From: Julian Evans <[REDACTED]>
Sent: 13 September 2021 12:22
To: Simon Davis
Cc: Anita Gardner
Subject: RE: P/111/21/RES - Sefter Road - Planning progress

From: Julian Evans <[REDACTED]>
Sent: 10 September 2021 11:57
To: Anita Gardner <Anita.Gardner@arun.gov.uk>
Cc: Simon Davis <Simon.Davis@arun.gov.uk>
Subject: P/111/21/RES - Sefter Road - Planning progress

Status Planning		
Scale 1:500@A3	Drawn By JE	Date June 21
Project No. 20156	Drawing No. P003	Revision C

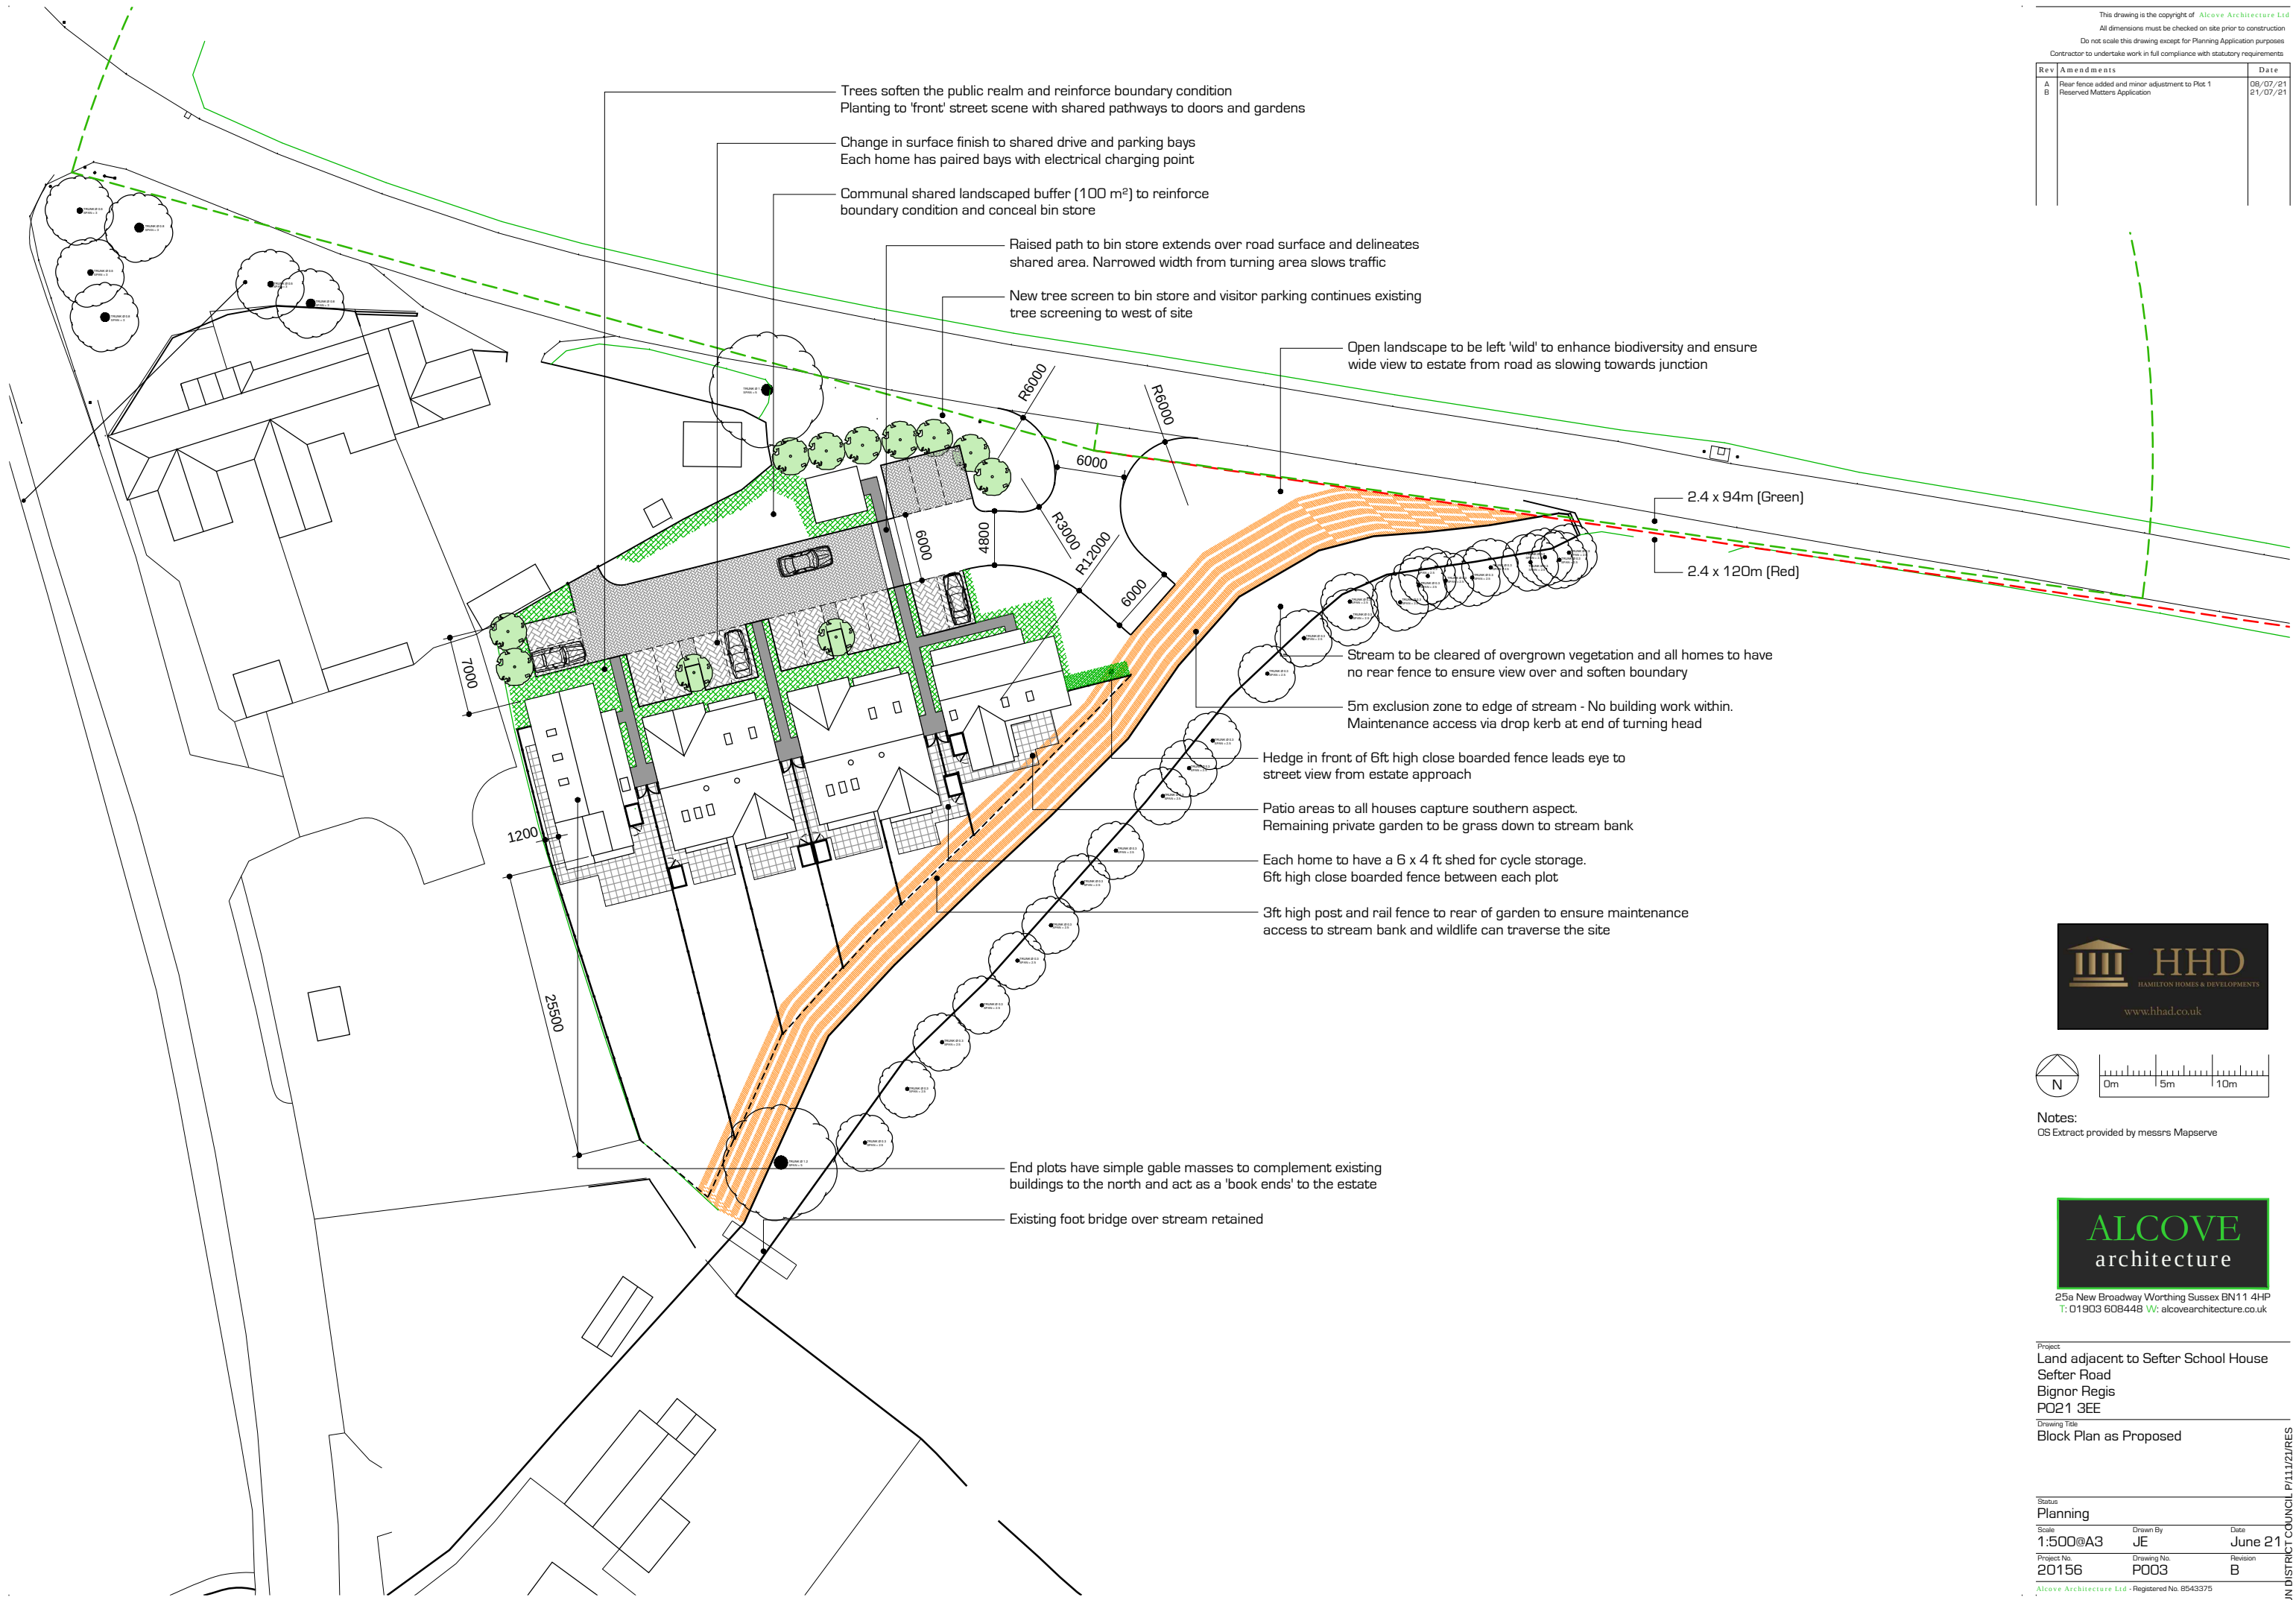
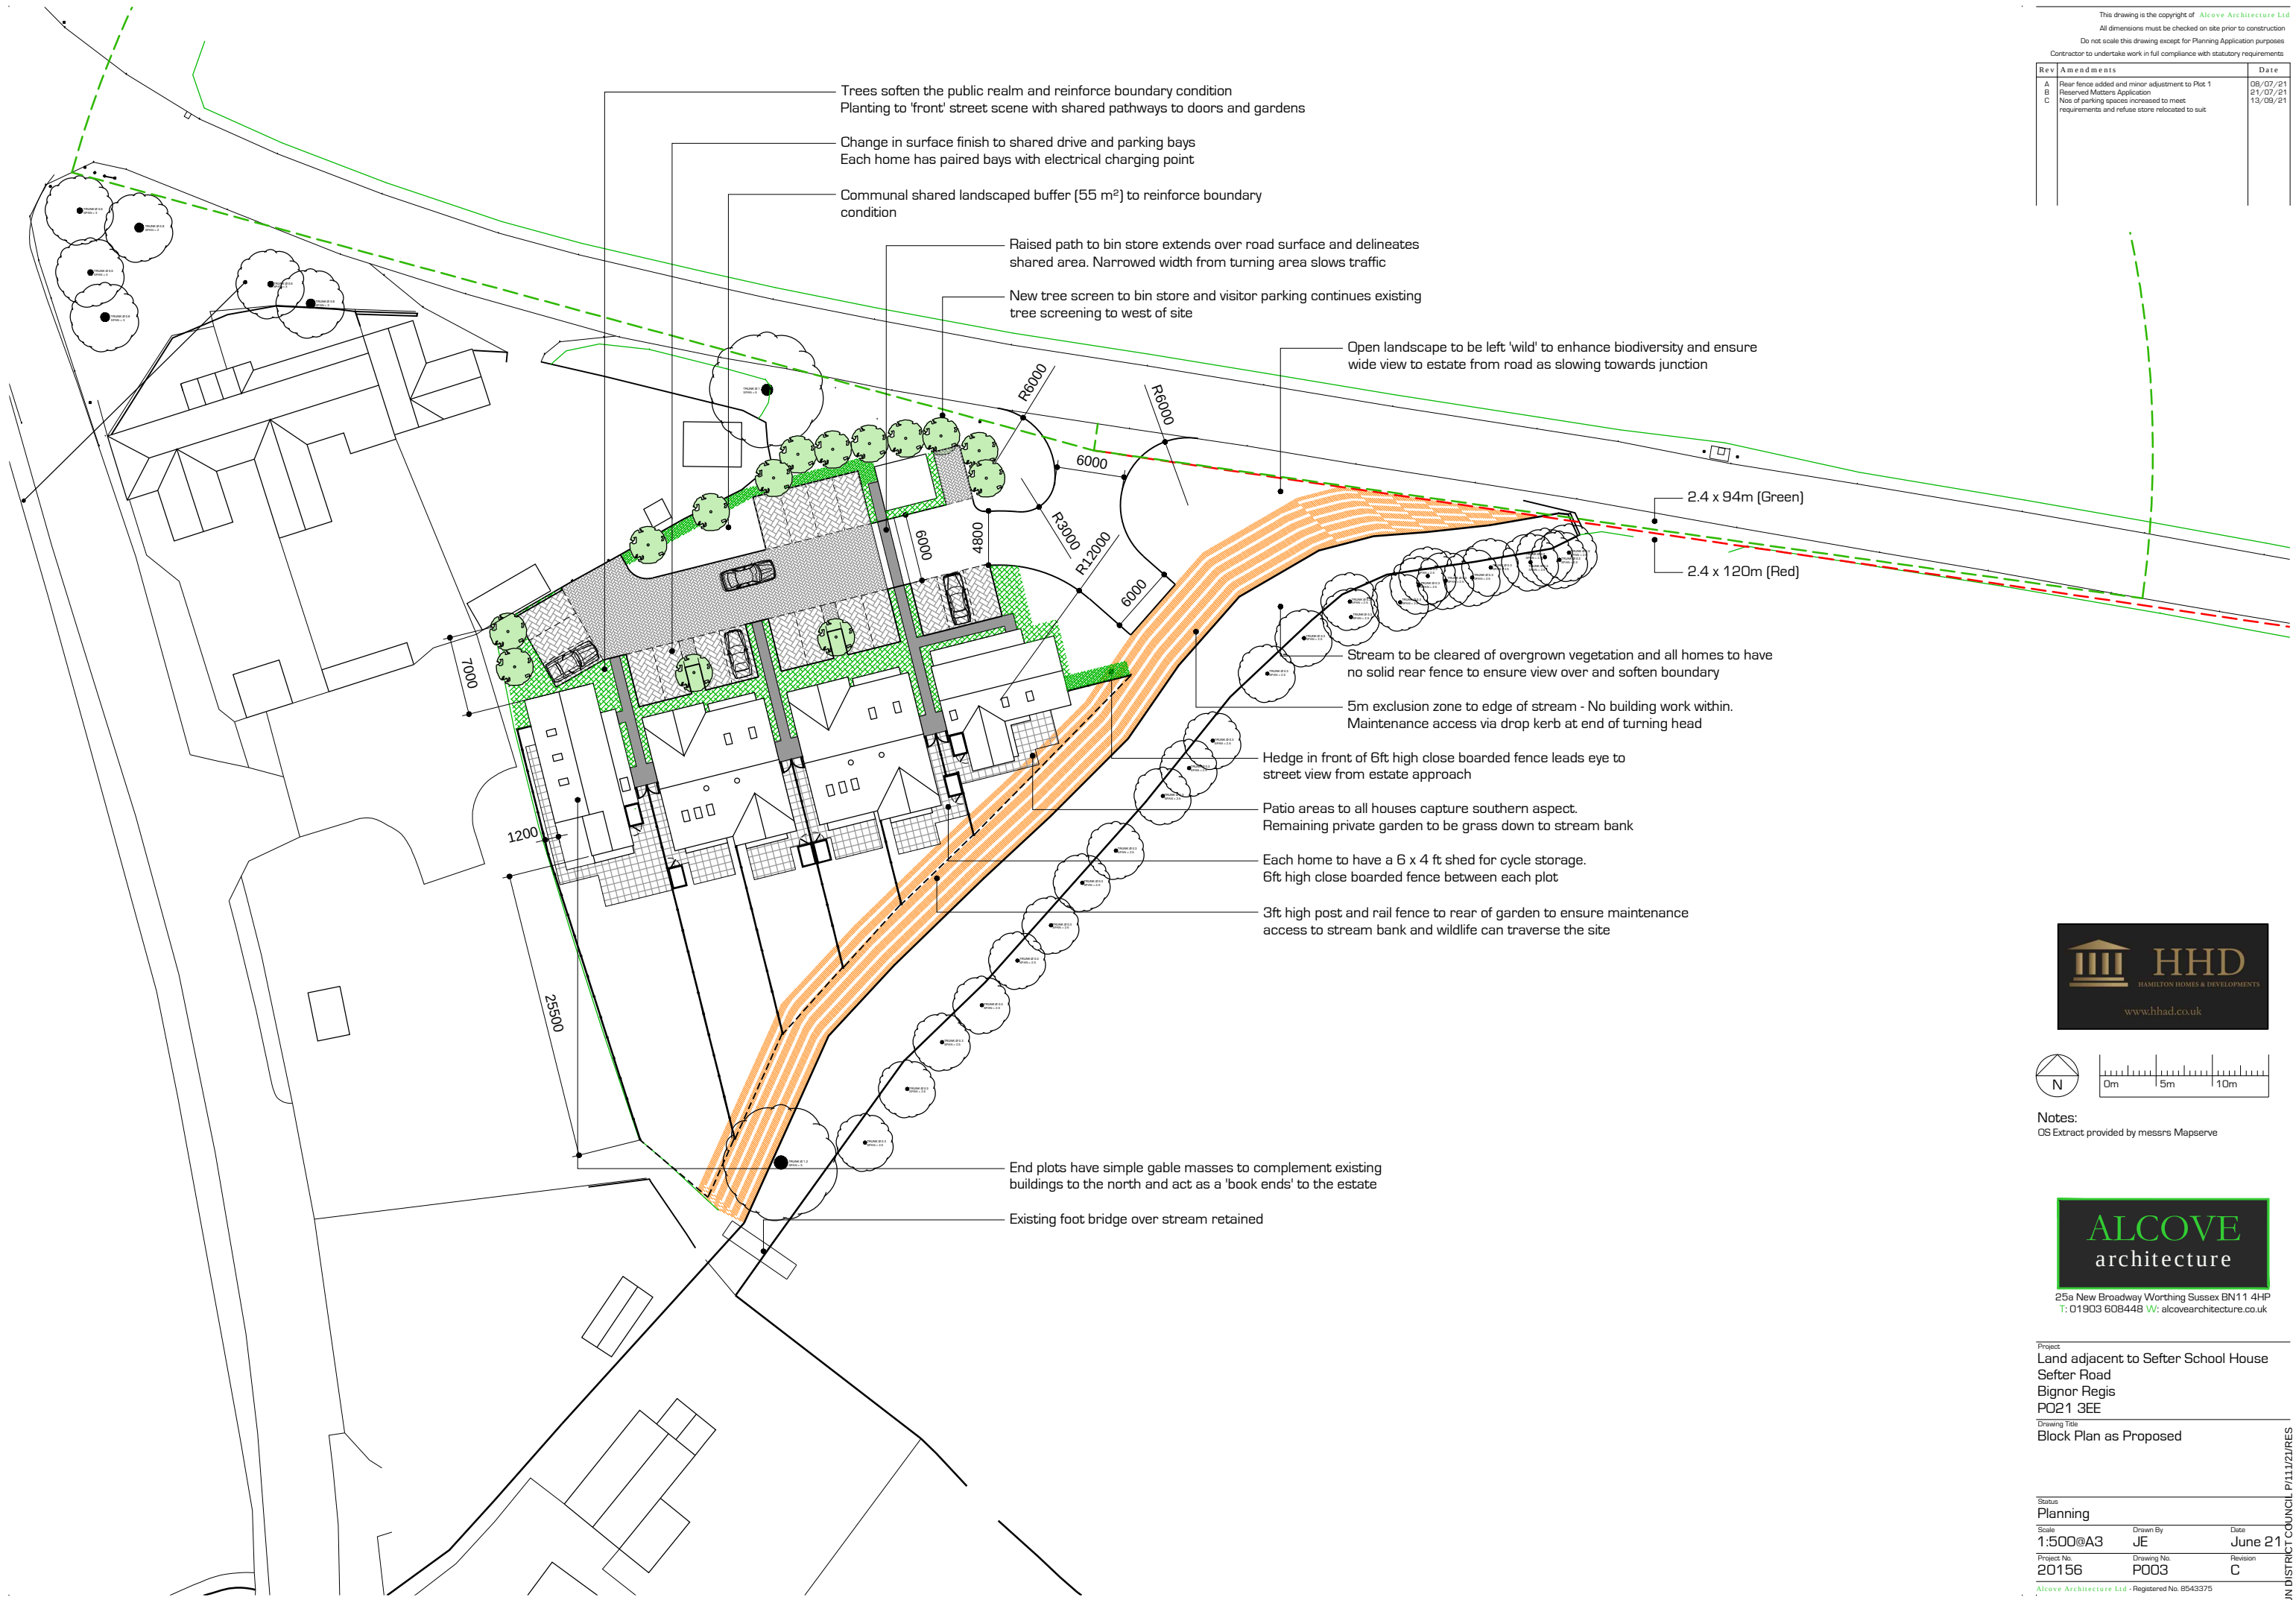
I have calculated the parking requirements per the APS as 3 per dwelling (18) plus 1 visitor so 19. On that basis, you are short by 4 spaces. Given the site location (limited accessibility by means other than the car), it is felt that parking should meet the requirements. I'll leave this with you to consider.

This was very useful to receive the clarification and in this regard, please find attached revised drawing nos P003C and P004C, which have been updated to accommodate the required parking spaces. In summary, the concept remains as before but with the 4no semi detached homes having their additional spaces placed opposite, with the refuse store relocated/mirrored accordingly.
